DECISION DELEGATED TO DEVELOPMENT MANAGER

Application No: H11-0508-20 **Applicant:** Mr S Portass
Proposal: Proposed residential development comprising 4 dwellings
Location: Rear Of 15, 17 & 19 Market Street Long Sutton Spalding
Terminal Date: 27th August 2020

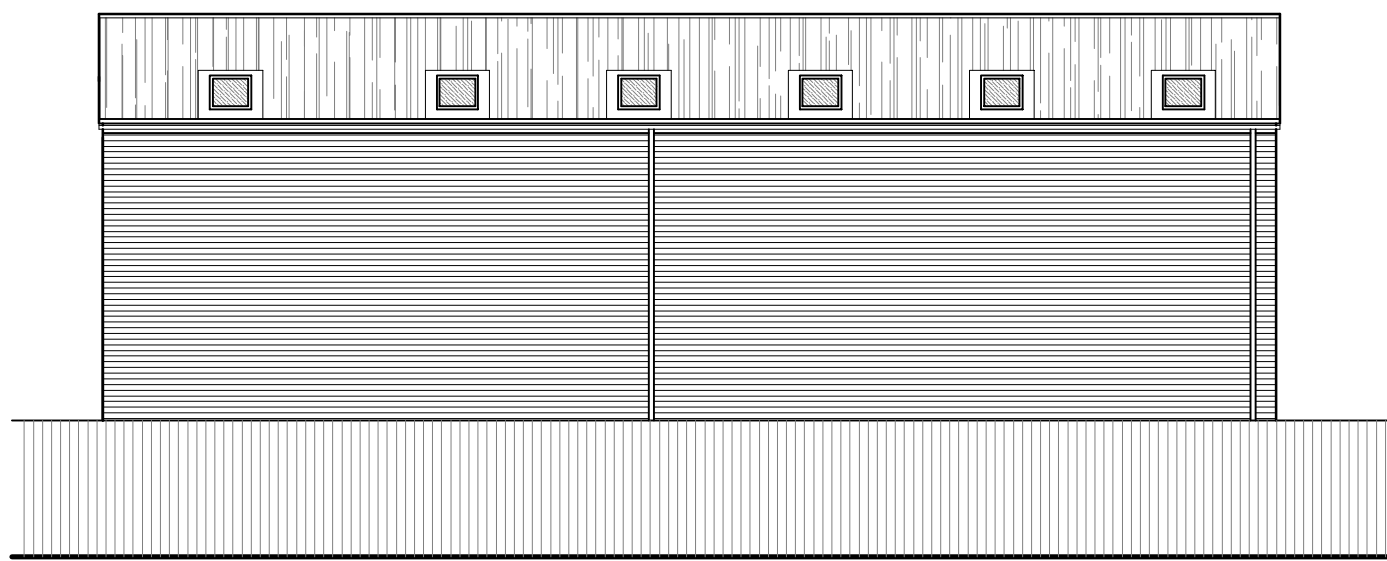
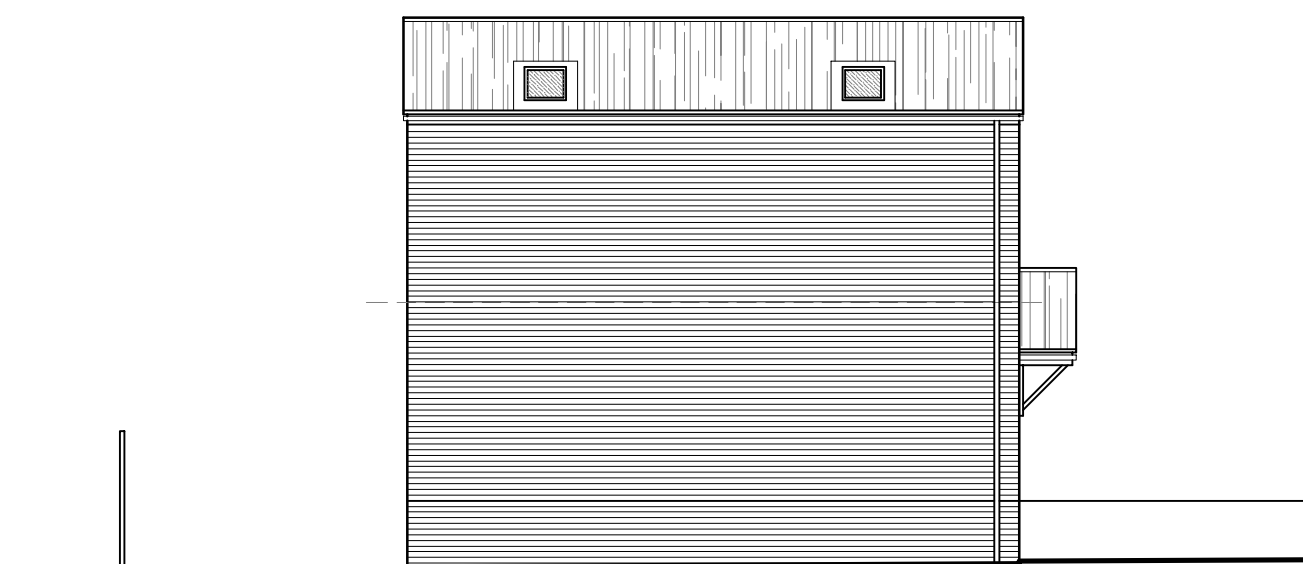
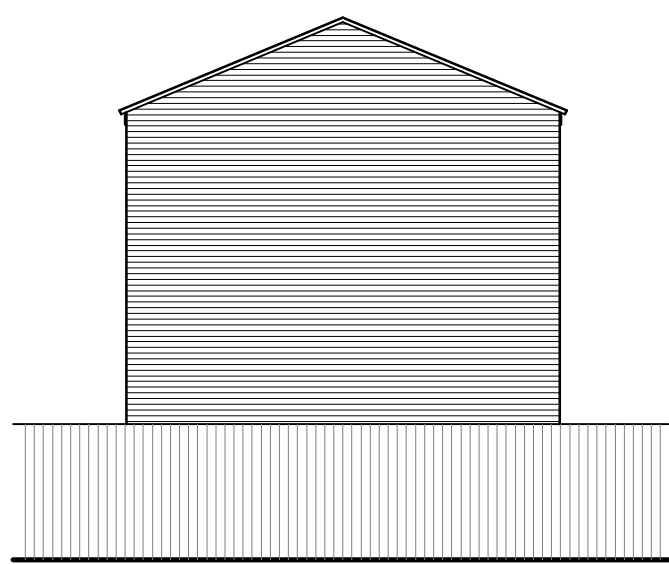
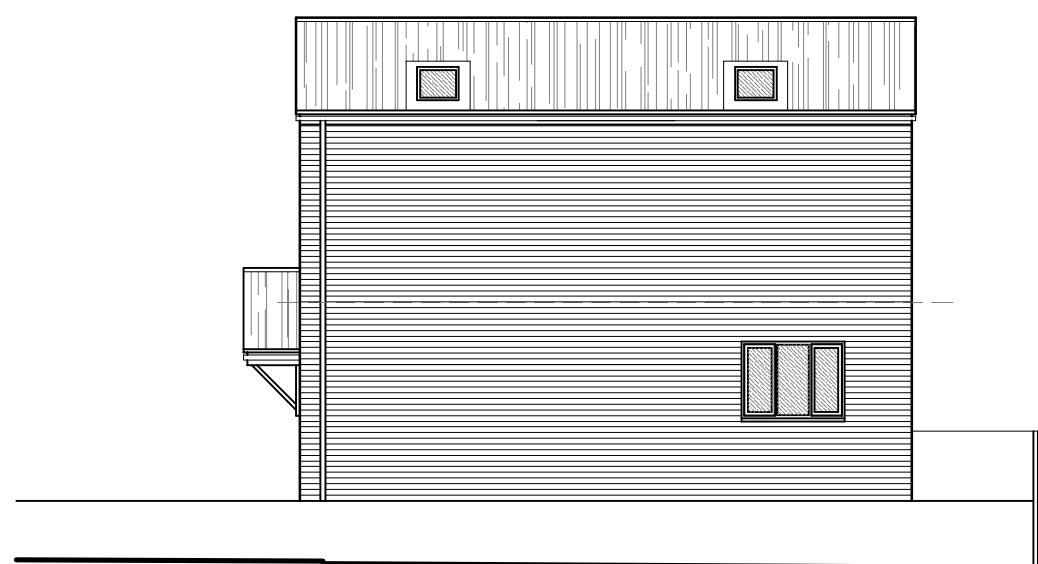
The proposed properties have blank elevations facing south and west, other than high level rooflights. The amenity of existing residents to the north-west and south-west would not therefore be materially harmed in terms of overlooking/lack of privacy, subject to appropriate boundary screening.

The site is approximately 700mm lower than neighbouring ground level to the south-east. The proposed dwellings have first floor bedrooms facing east at a distance of less than 6 metres from the neighbouring boundary. In respect of the previous scheme, it was recommended that an existing wall along the eastern boundary be increased in height from 2.1 metres to 3.3 metres on the neighbours side to protect the amenity of residents within supported housing to the south-east. This would be of sufficient height to protect the privacy of neighbouring residents in respect of the current scheme. It is therefore considered that the development would not have a significant adverse impact on adjacent residential amenity by reason of overlooking/lack of privacy.

The main block would sit on the same footprint as the former two-storey workshop, albeit being longer than that building. That additional length would overshadow a footpath, side entrance door and kitchen window in the gable of the property immediately to the north-west of the application site, primarily during the morning. In respect of the previous application (ref. H11-0275-14), the view was taken that the overshadowing would not be so harmful to the amenity of that property that permission should be refused on that ground. However, the buildings have now been increased in height, which would have a greater impact upon the neighbouring property in terms of overbearing effect and overshadowing.

The design of the previously approved scheme (ref. H11-0275-14) reflected the industrial character of the former timber workshop, which was subservient to the principle buildings facing Market Street to which it related. The buildings now proposed are higher and more standard in terms of appearance, giving the appearance of a modern terrace rather than a converted historic workshop. It is considered that the proposed scheme, by virtue of its scale, form, detailing and materials, would harm the character/appearance of Long Sutton Conservation Area and also the setting of nearby designated and non-designated heritage assets, including no. 21 Market Street to the north, which is grade II listed.

BLOCK PLAN 1:500

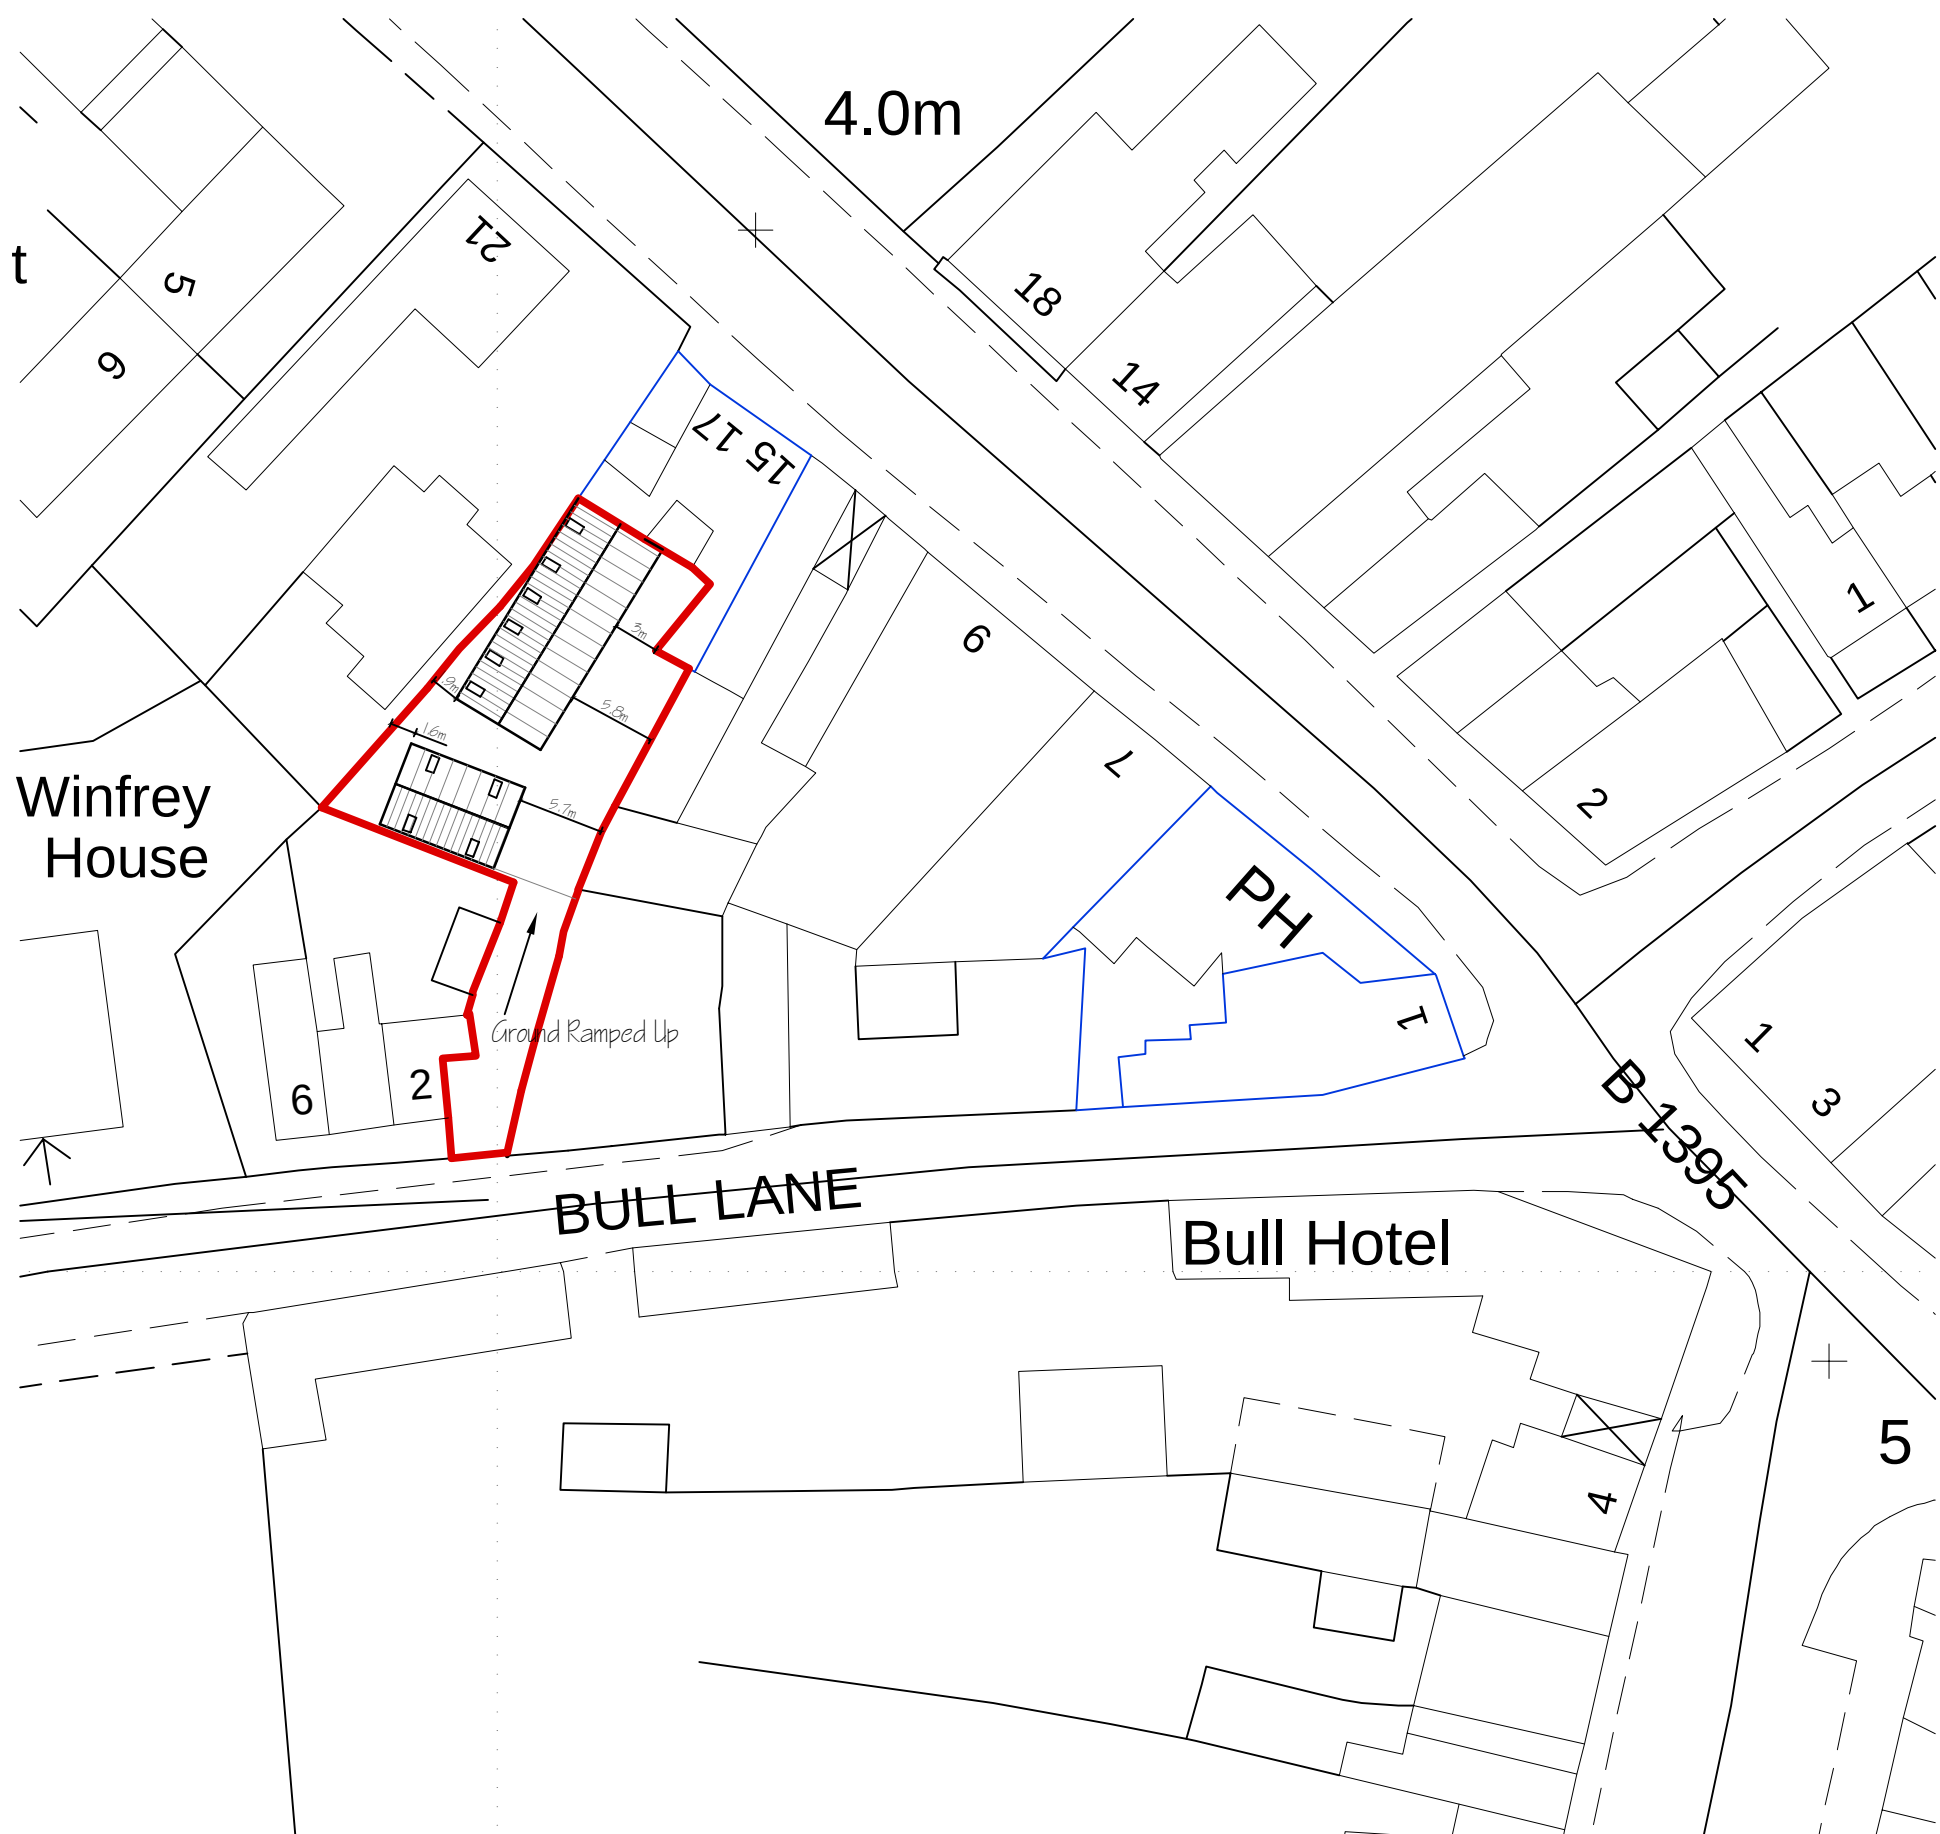
Moreover, each dwelling would have no or very little private external amenity space and would have shared access facilities with occupants of nos 15-19 Market Street to the north.

No on site parking facilities are indicated shown on the submitted drawings. The proposal does not therefore comply with Policy 36 of the South East Lincolnshire Local Plan. However, on street parking facilities are available nearby and the site is within Long Sutton town centre and on a public transport route for those without a motor vehicle. The County Highways Authority has raised no objections on highway safety grounds.

Also, the proposal would constitute a form of overdevelopment. Each dwelling would have no or very little private external amenity space, along with shared access facilities with occupants of nos 15-19 Market Street to the north. Moreover, the increased height and scale of the development would be such that it would have a greater impact upon the neighbouring property to the north-west in terms of overbearing effect and overshadowing.
